Pre-Design Investigation
(Additions)

DATE 11-14-88

ADDRESS 1623 Los Tomases ZONE ATLAS # J14/D81

PROPOSED DEVELOPMENT 900# ADDN.

W. Reed Edge1, W.S., P.E. CONSULTING ENGINEER 601 VASSAR DR NE ALBUQUERQUE, NM 87104 15051 252 2875	
STORAGE BUILDING STATKUS ENGINEERS	11/3/88
JOB # 88019 LEASE-A PORT/JONES STATUS	
1/16" = 1' 0" SIZE C	SH 1 OF 2

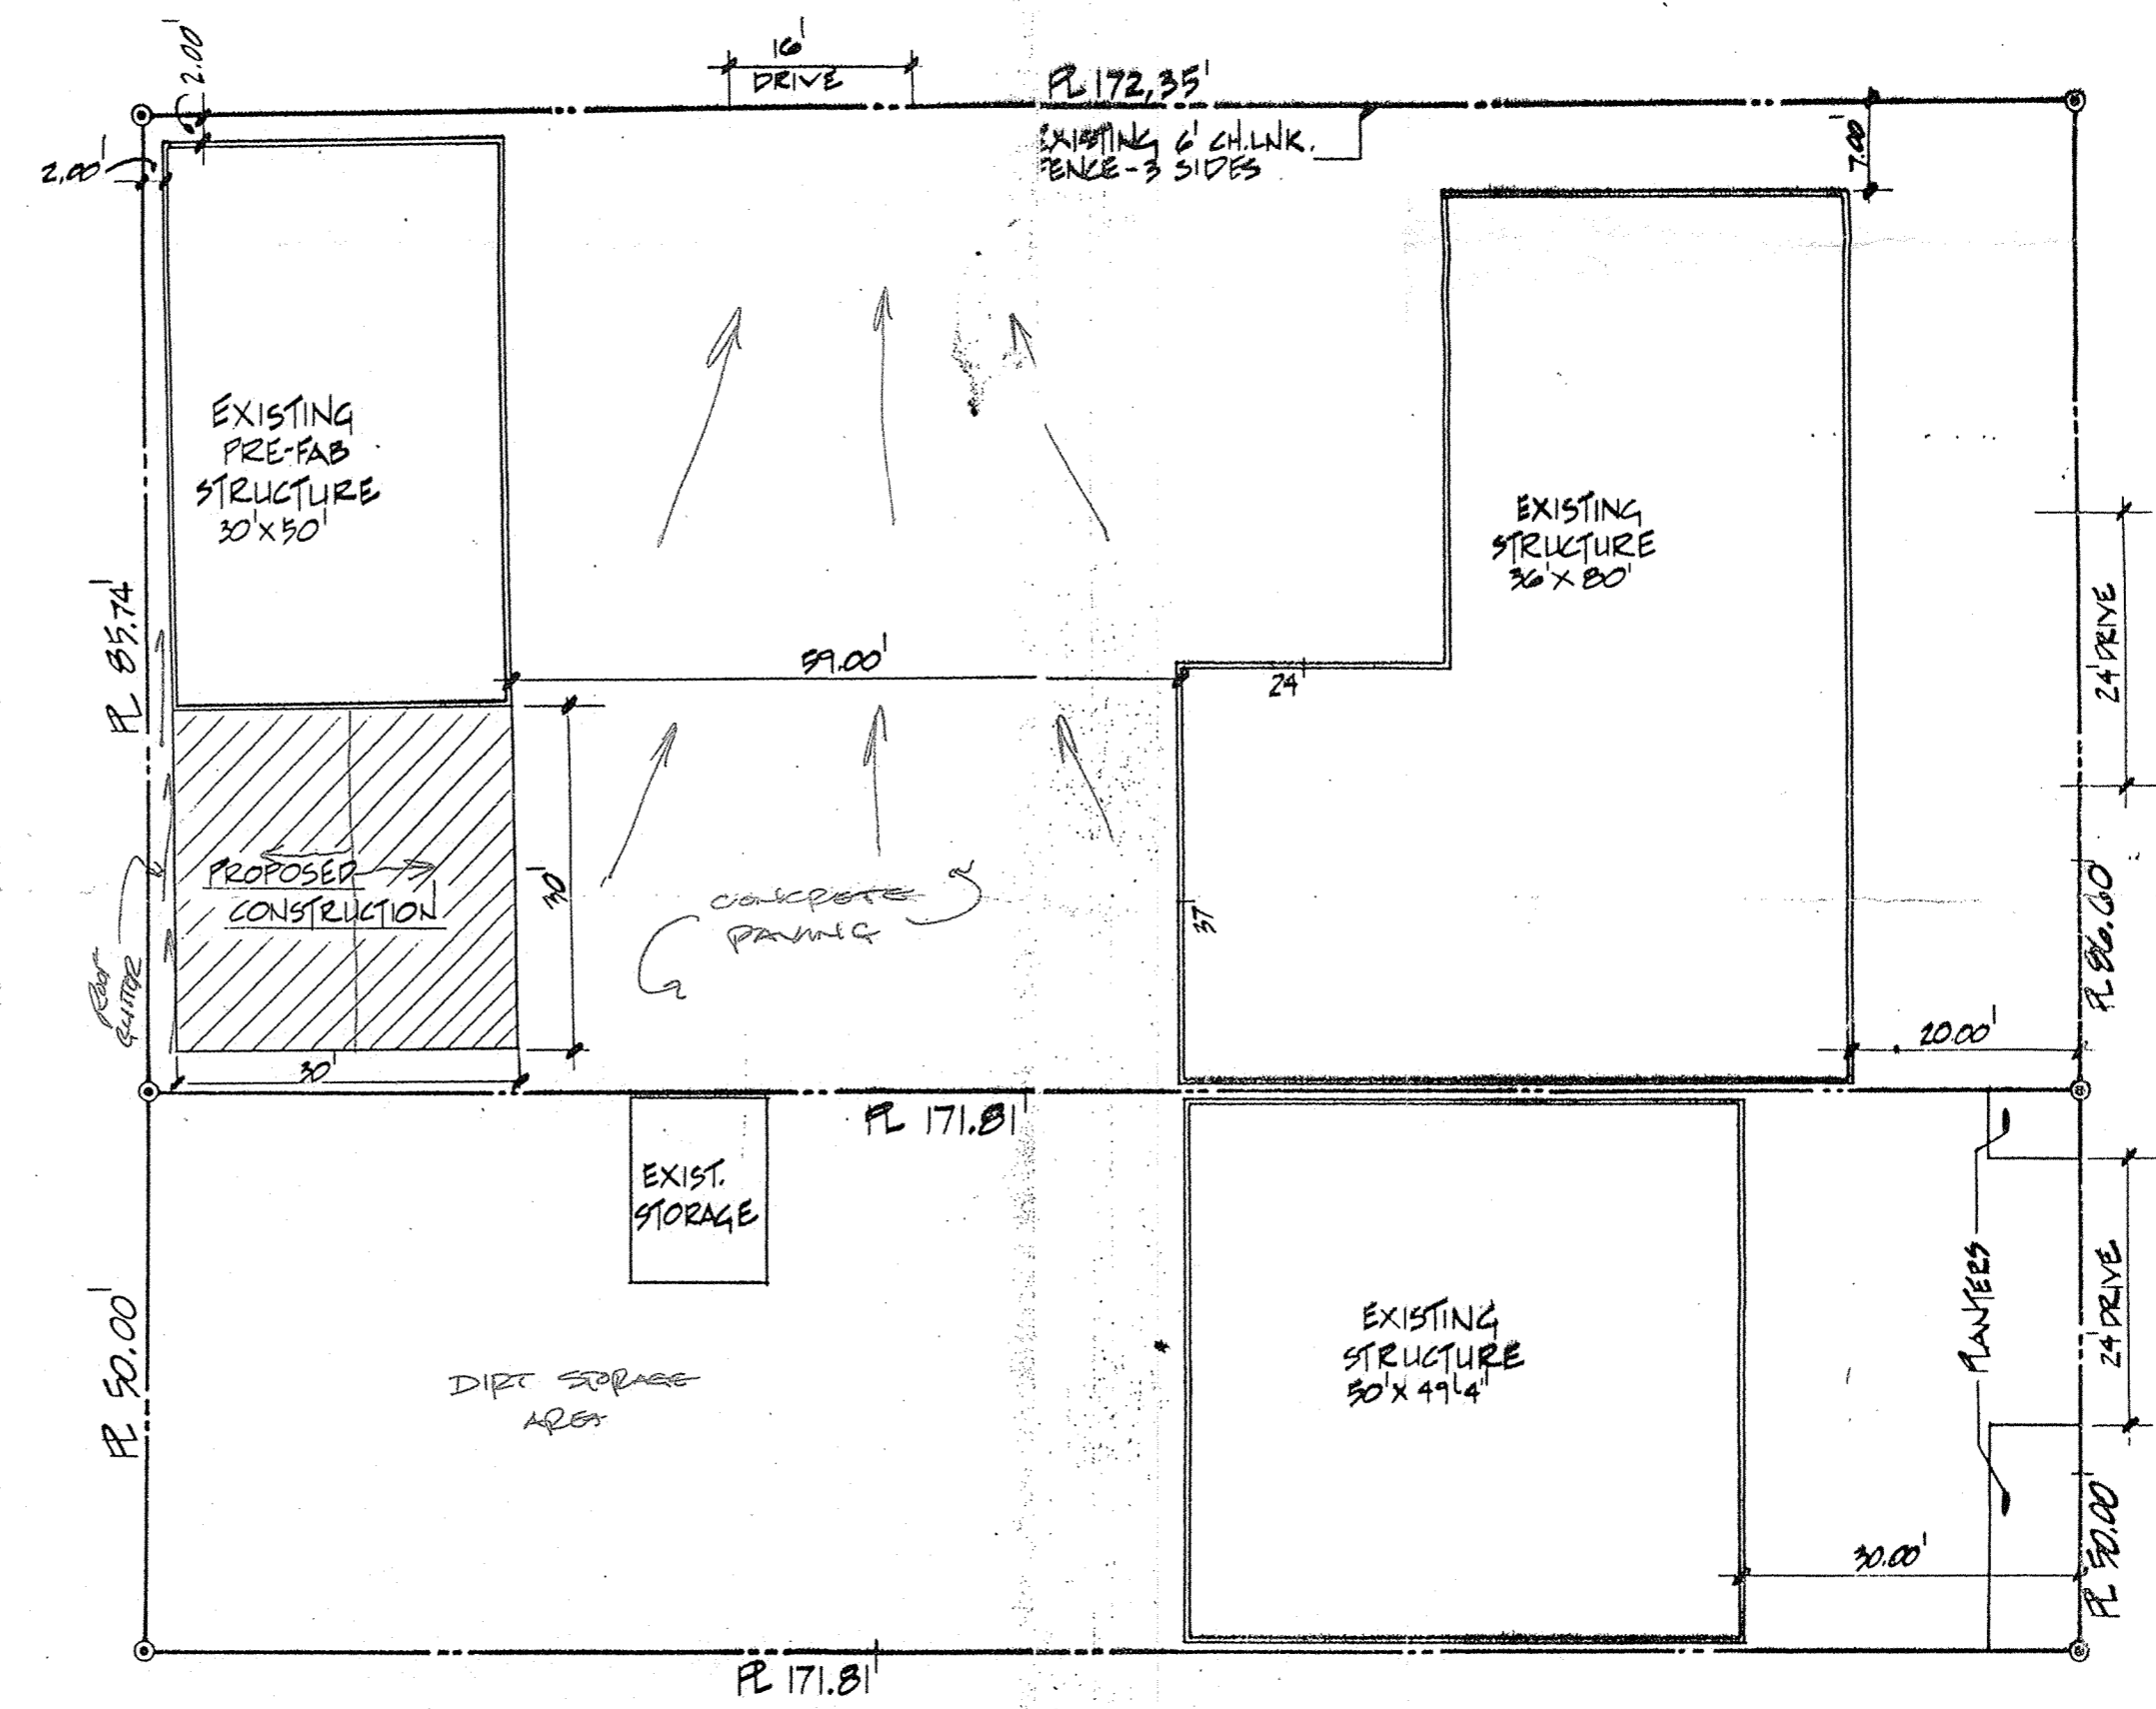
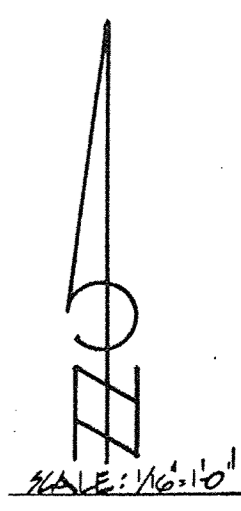
EAST HALF OF ADDN. DRAINS ONTO EXISTING CONCRETE

DRIVEWAY EXITING SITE THRU DRIVEWAY INTO ASPHALT

WEST HALF OF ADDN WILL NEED ROOF GUTTER TO

CHANNEL WATER INTO RIGHT-OF-WAY & NOT INTO ADJACENT PROP.
